Planning Inspectorate

Our Ref: EN010155

Application by FVS Dean Moor Limited for an order granting development consent for the Dean Moor Solar Farm project (EN010155)

Advice following issue of decision to accept the application for examination

- Legend**
- Order Limits
 - Street Works
 - Street work location reference (Schedule 4)
 - Proposed alteration of street
 - Alteration of street location reference (Schedule 5)
 - Existing access to be improved
 - Means of access location reference (Schedule 7)

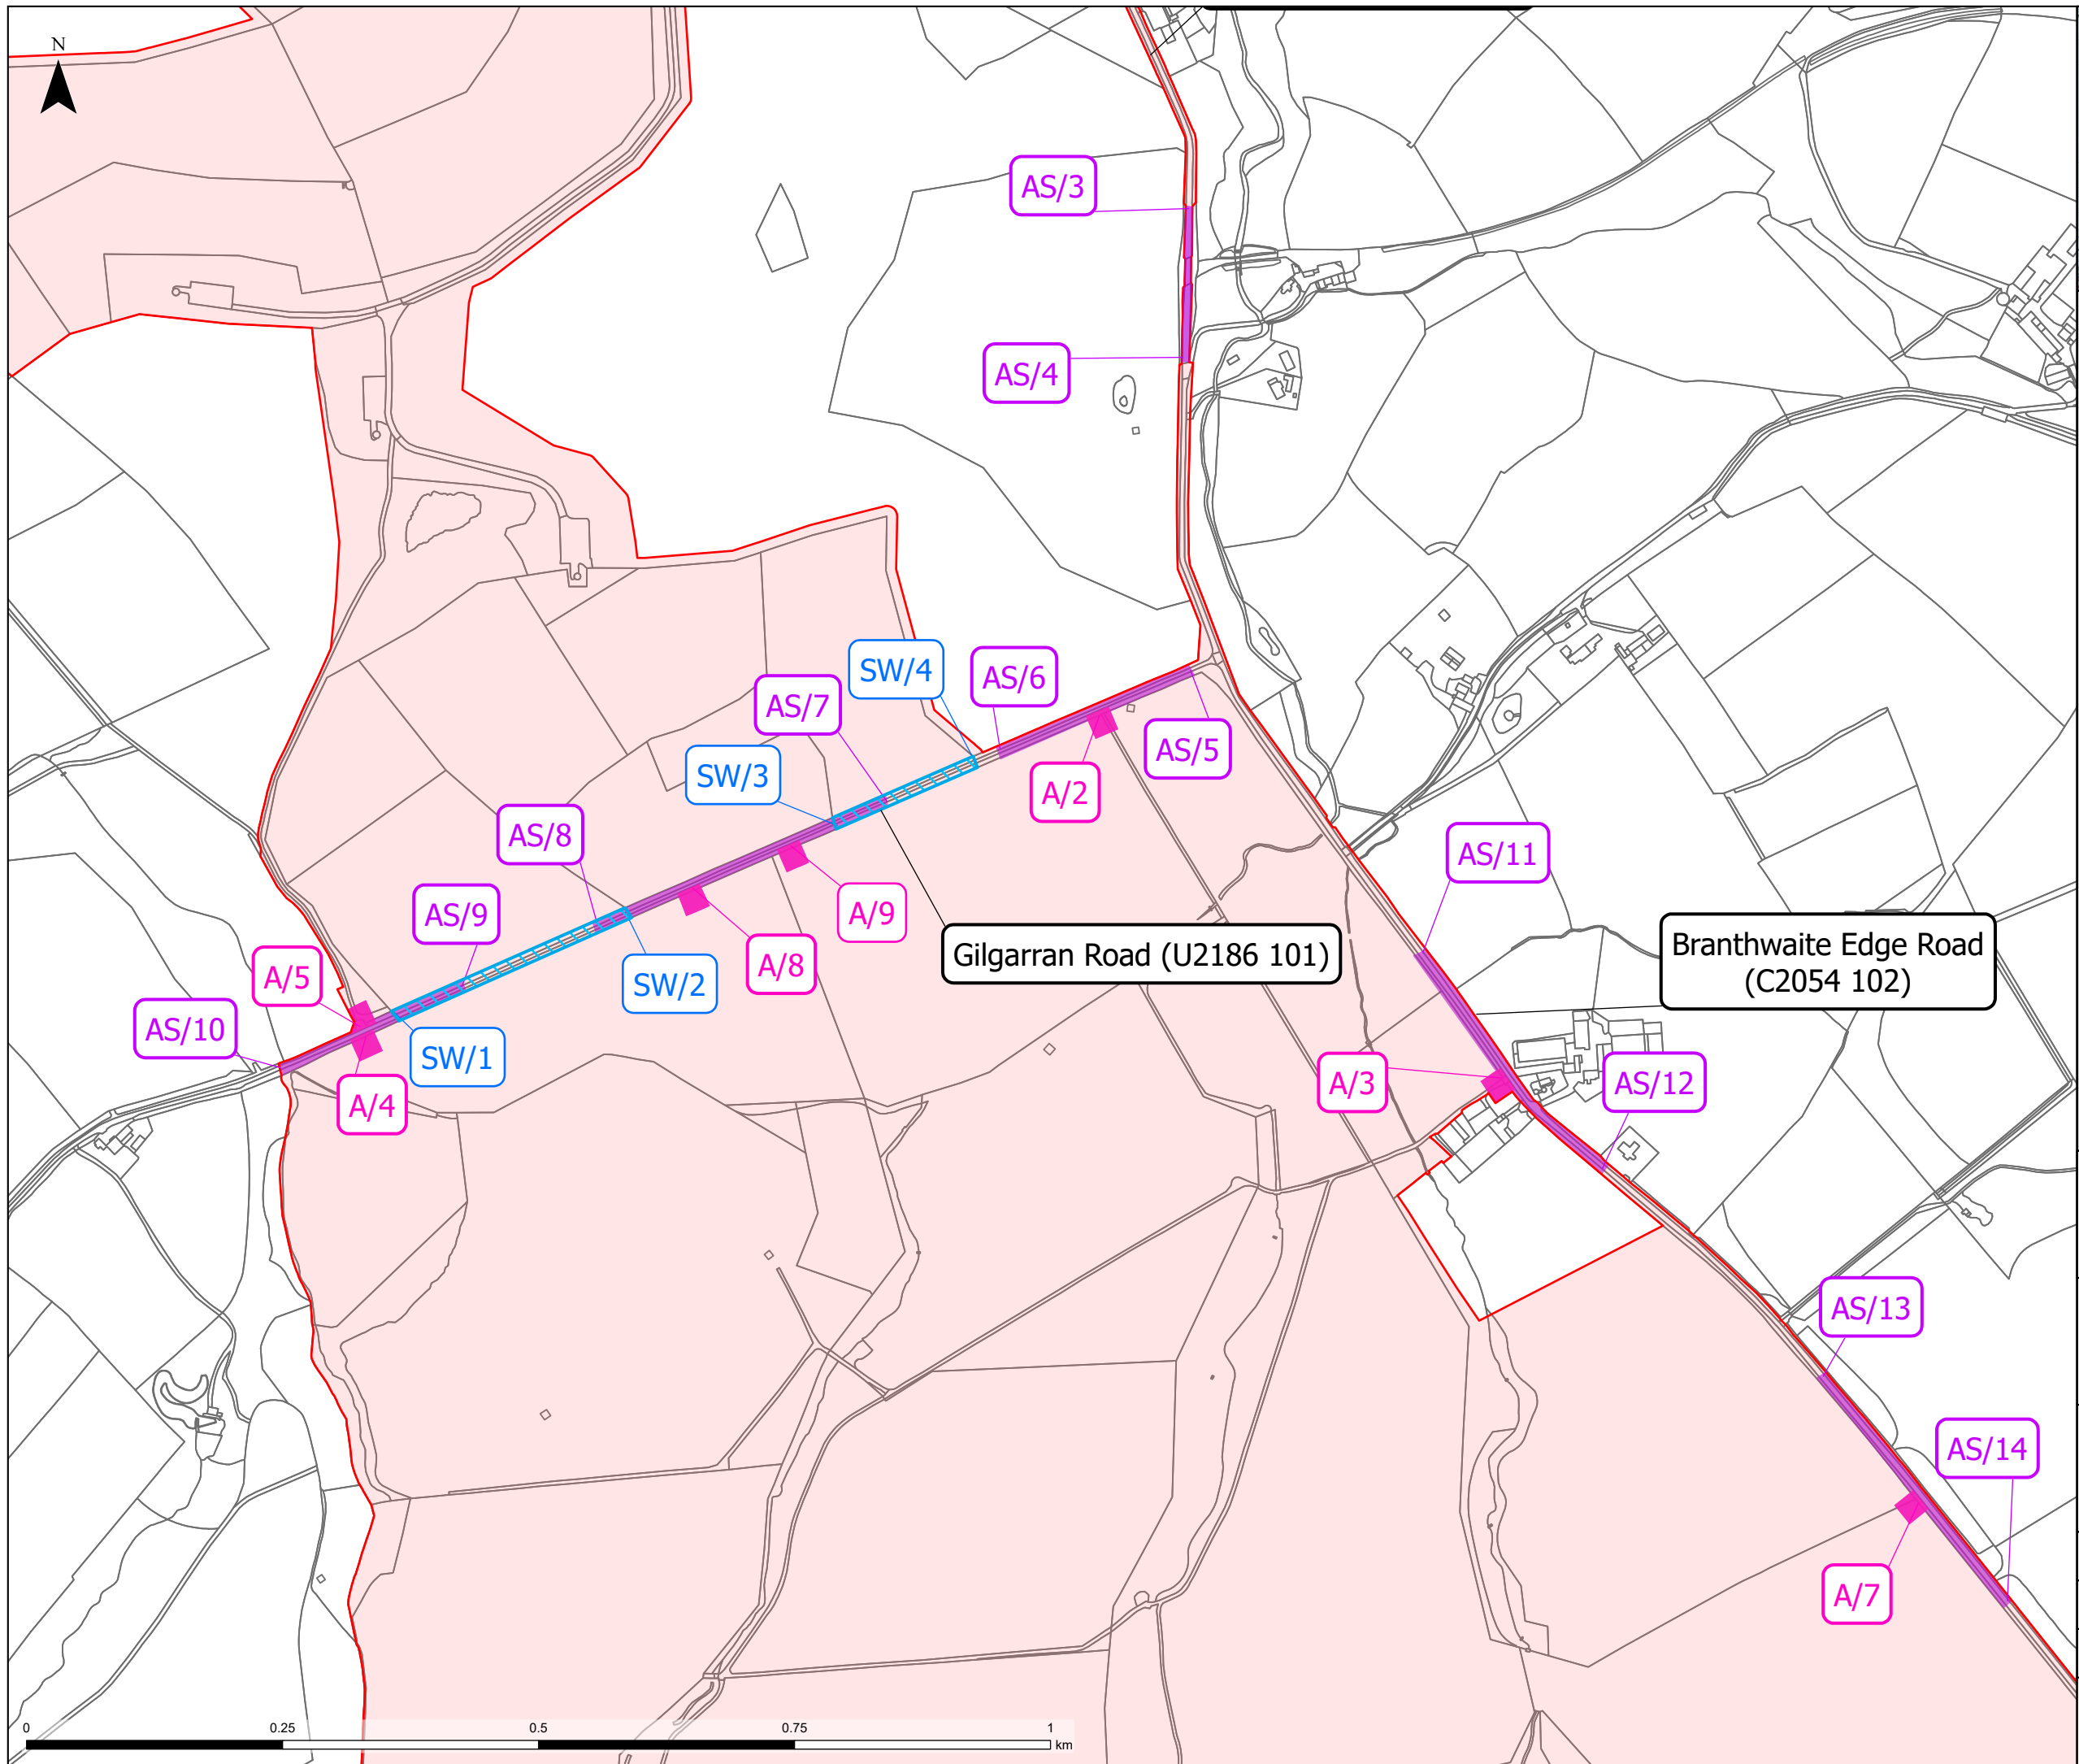
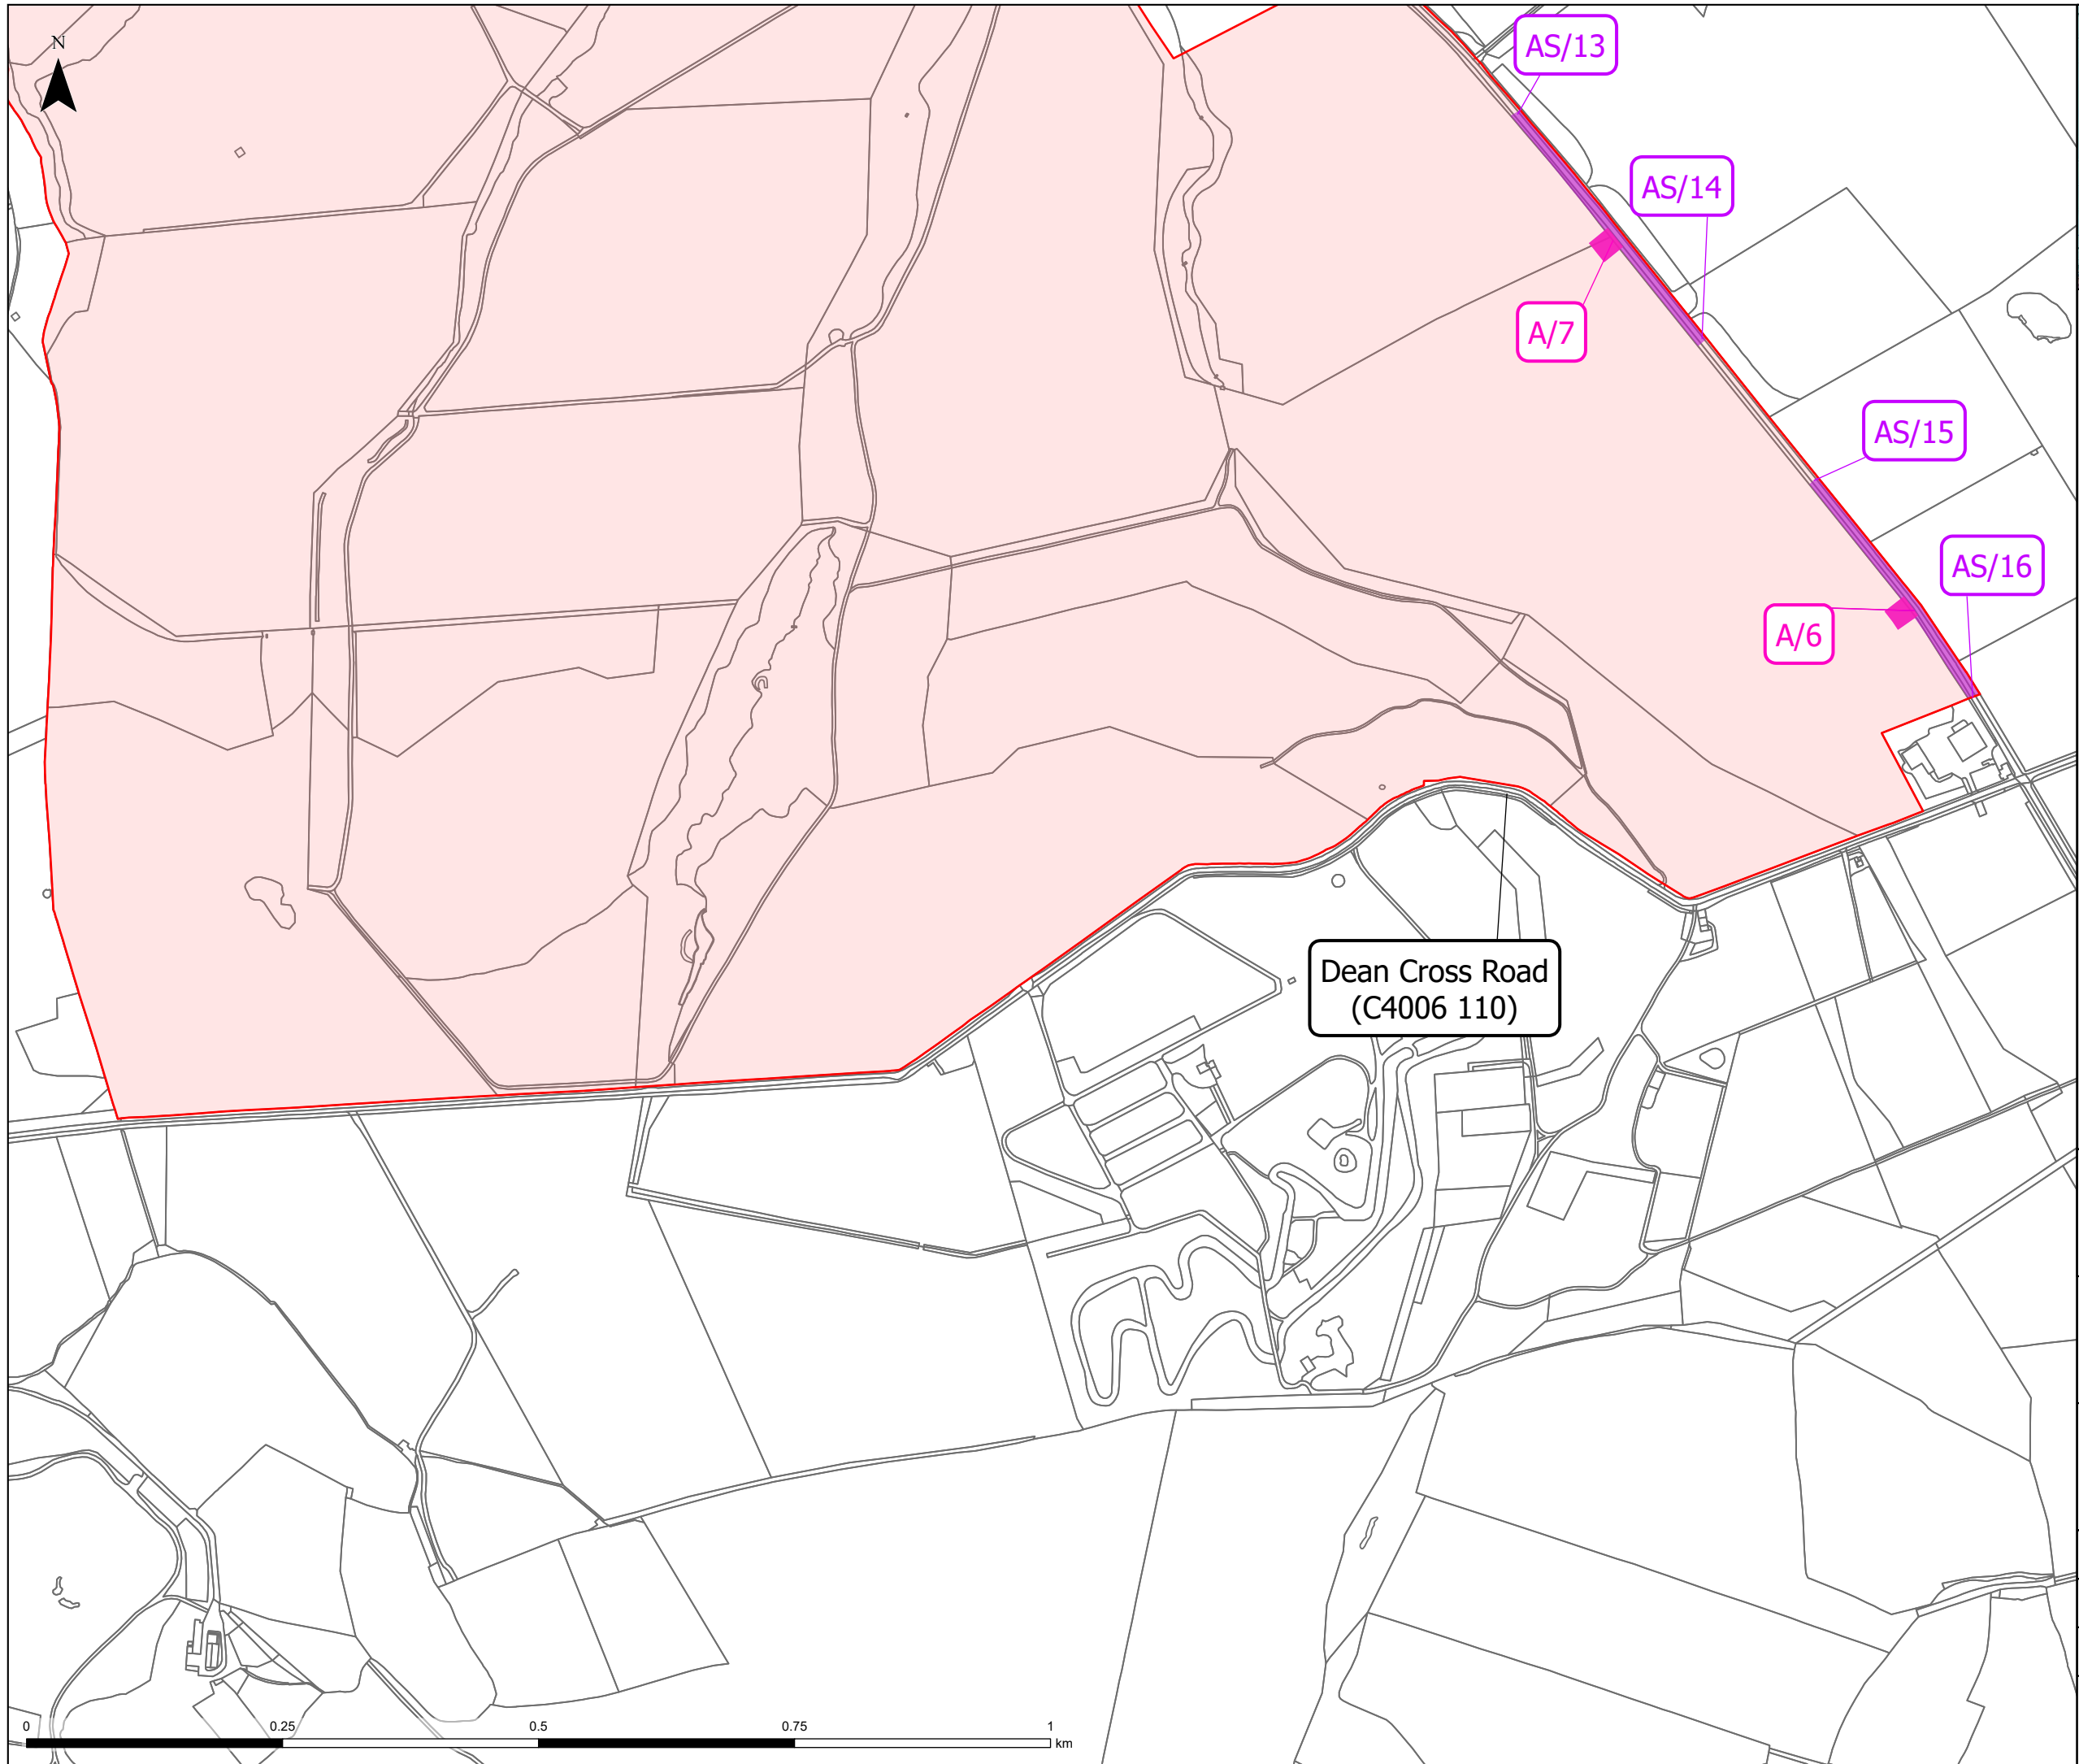
Streets and Access Plans (Doc 2.4)

The plans do not have any road names as identified in the dDCO.

Client		
FVS Dean Moor Limited		
Title		
DEAN MOOR SOLAR FARM DEVELOPMENT CONSENT ORDER REGULATION 5(2)(O) Traffic Regulation Measures Plan Version 2		
Scale: 1:5,000 @ A3	Date: 04/06/2025	
Drawn: TL	Checked: TH	
Reference: 2.5	Sheet 1 of 1	Version 2

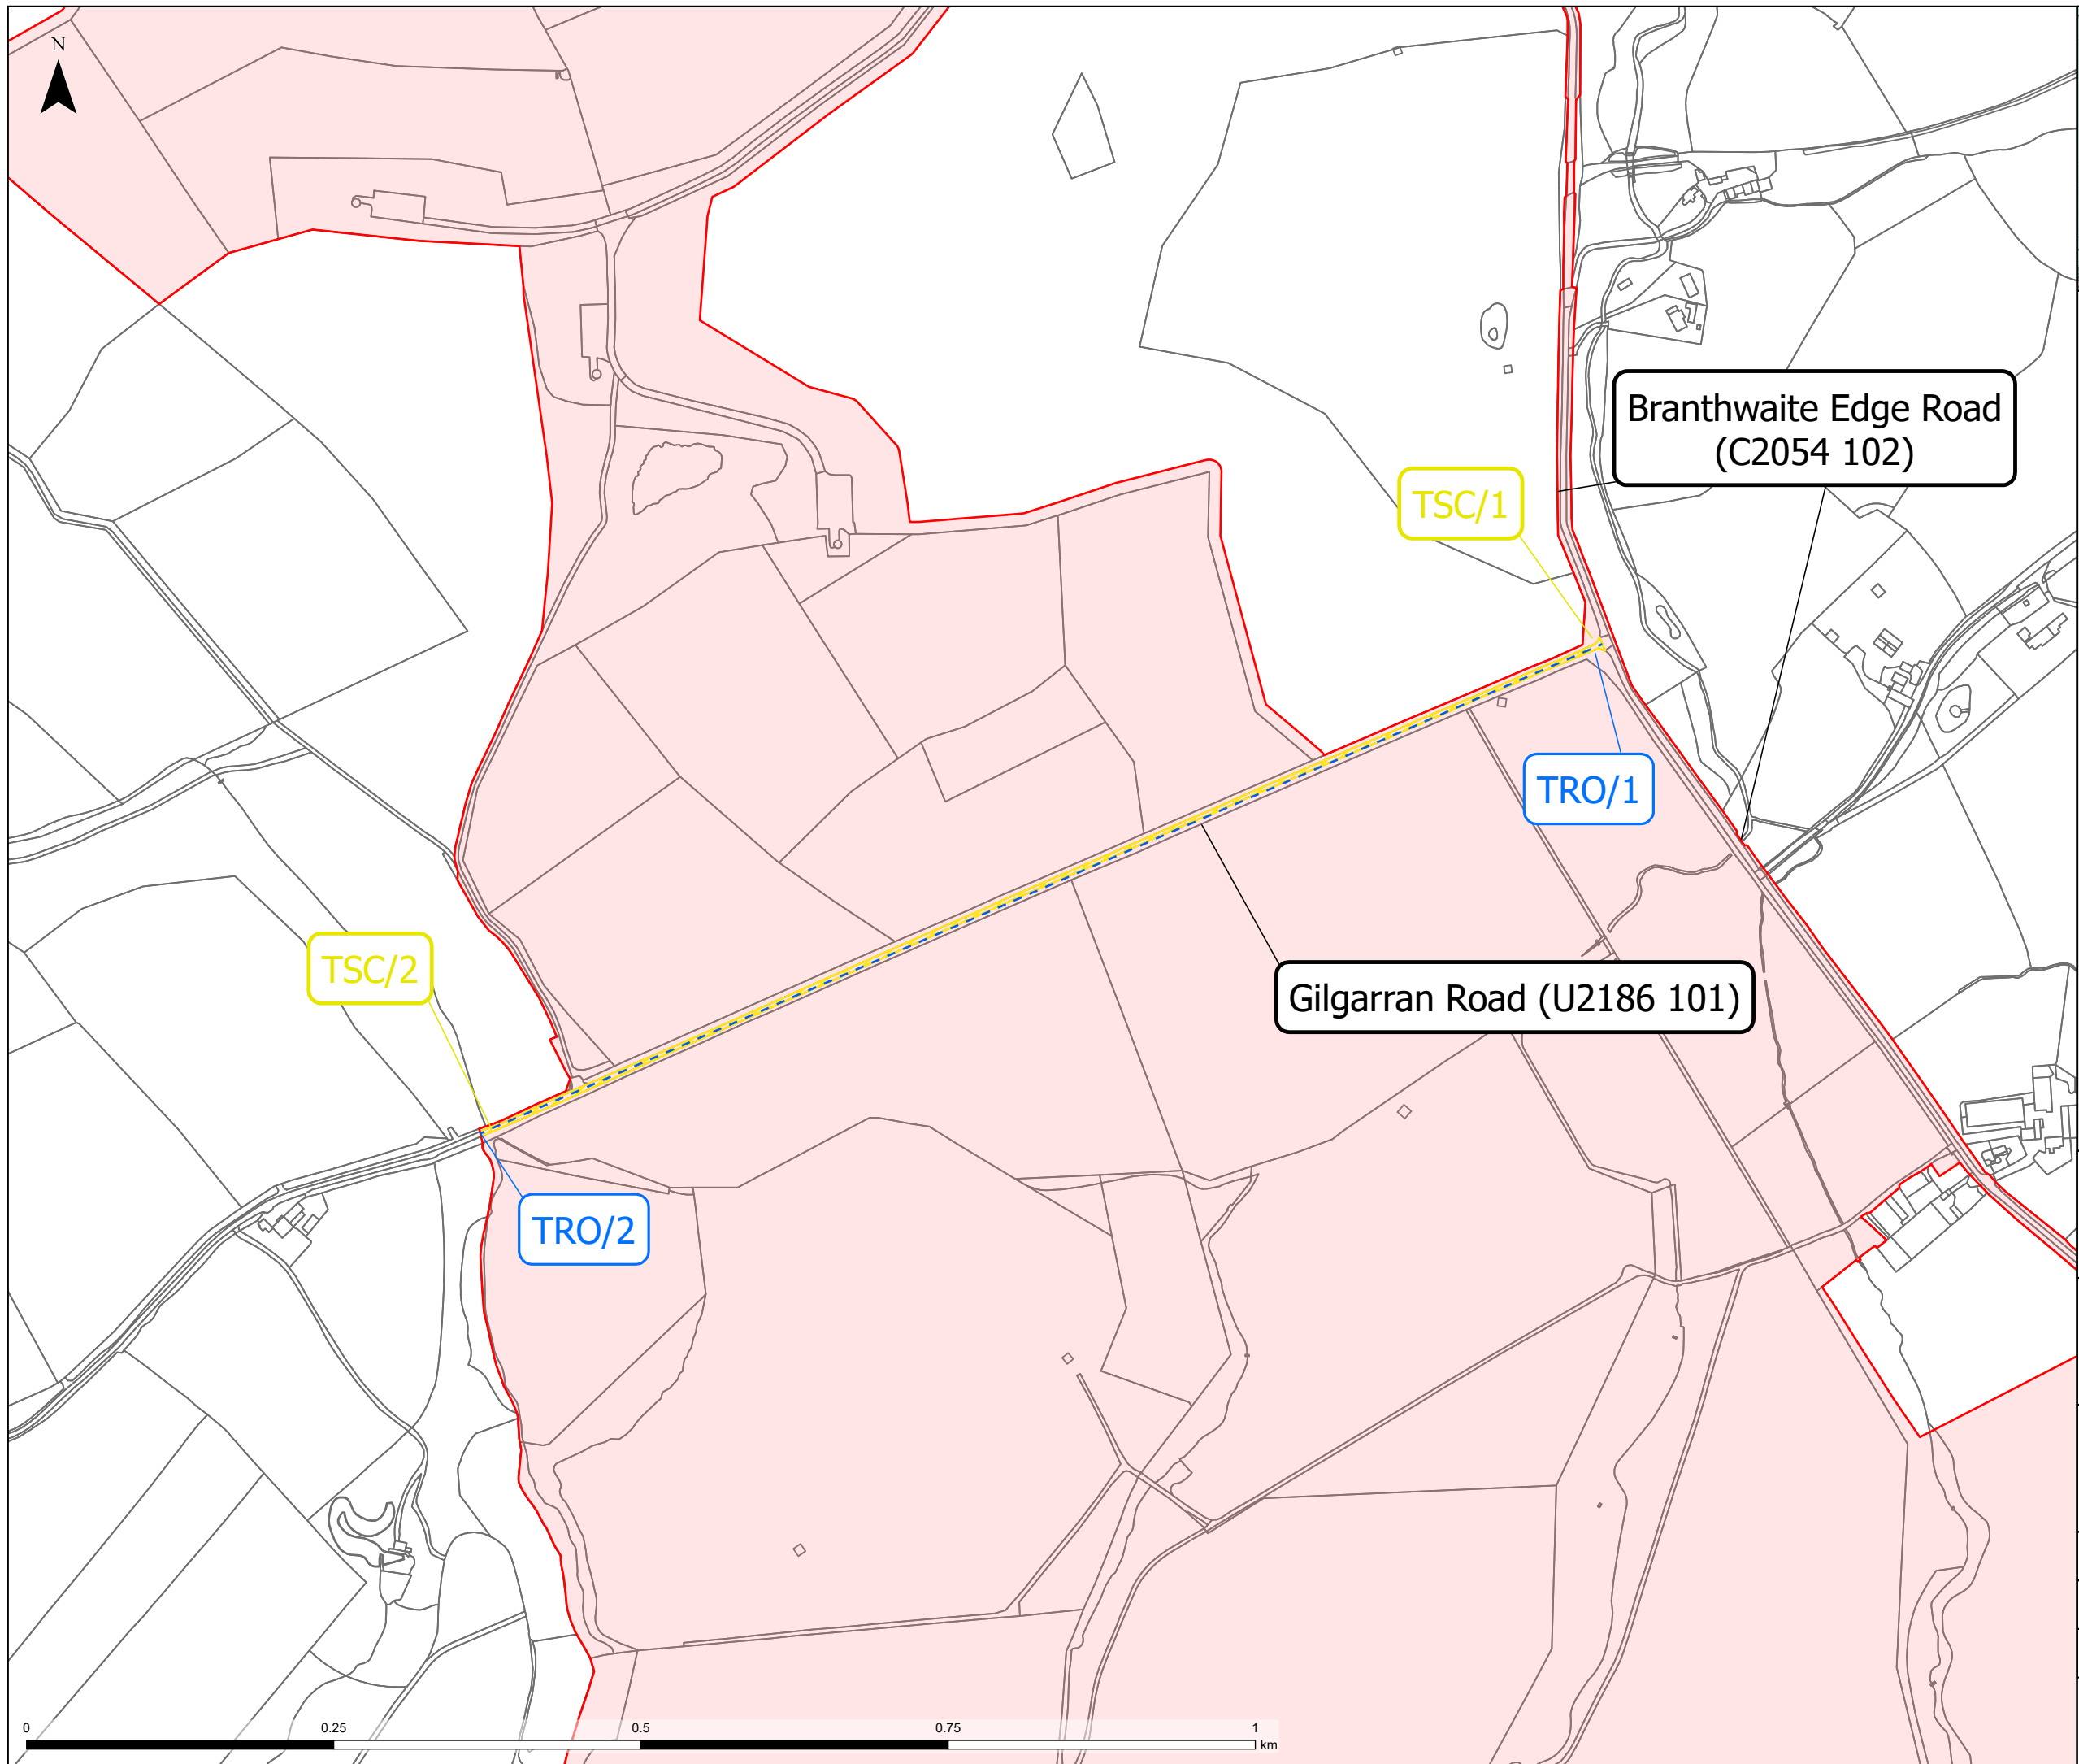
Traffic Regulation Measures Plan (Doc 2.5)

The plan does not have any road names as identified in the dDCO.

Schedule 6 of the dDCO states points TSC/1 and TSC/2 hatched yellow on the plan, but the colour on the plan is orange.
